Application number: 2024/92647	
What is the application for?:	Erection of detached dwelling with detached garage
Address of the site or building:	Land at Occupation Lane, off Birkby Road, Huddersfield, HD2 2ES
Postcode:	HD3 4EY

Drawing title
**Garage Floor Plan and Elevations as
Proposed**

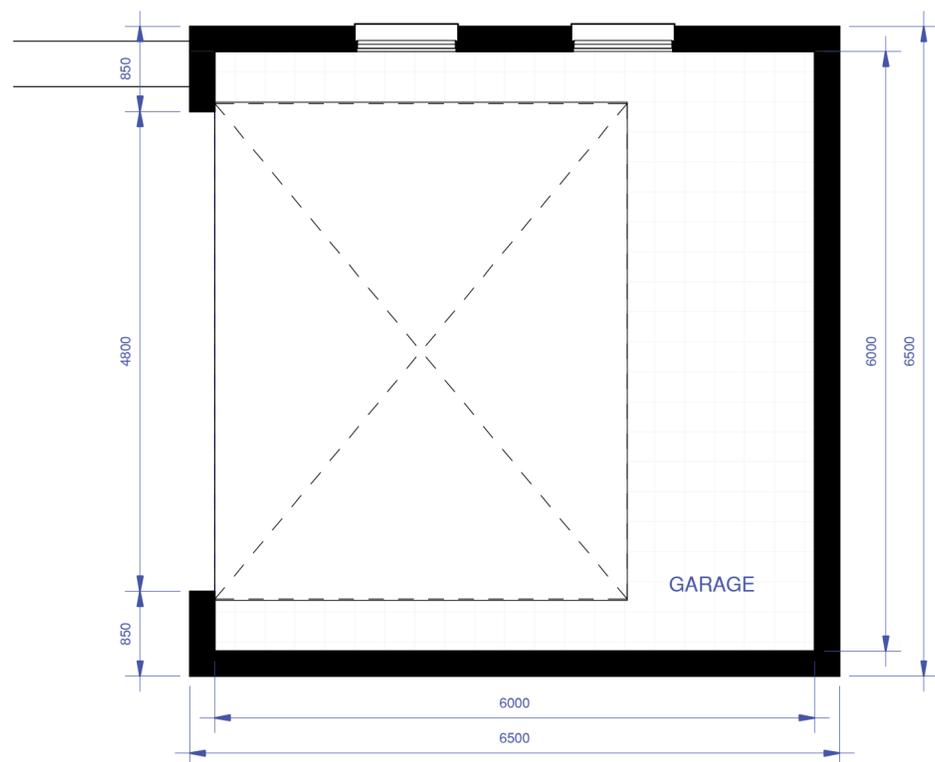
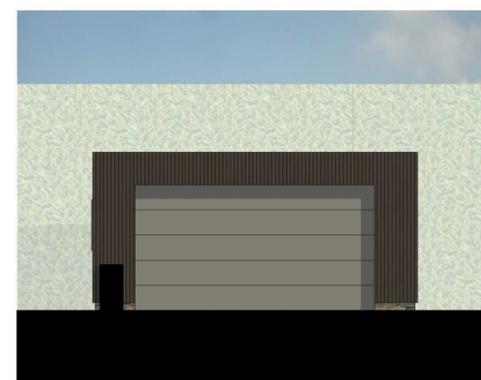
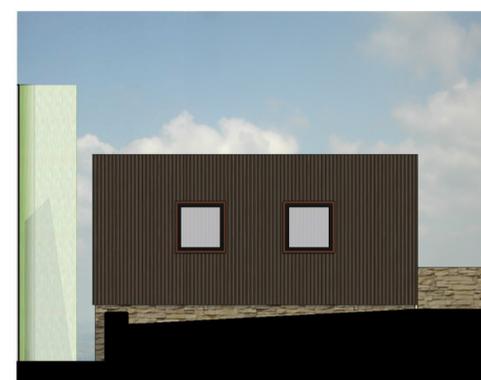
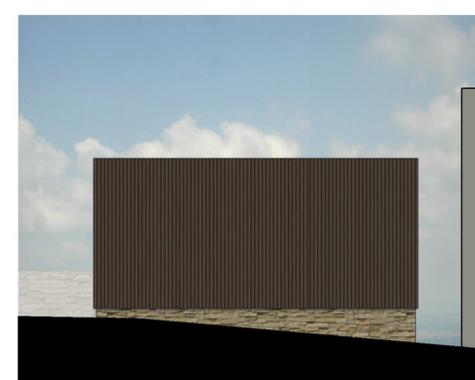
The proposed bungalow, with a flat roof and proximity to boundaries, is inconsistent with the area's character and visually disruptive. The design does not blend with local architecture and detracts from neighbourhood aesthetics, violating Policy LP24(a) and Chapter 12 of the National Planning Policy Framework. Furthermore, plans to remove a traditional dry stone wall undermine the area's unique character.
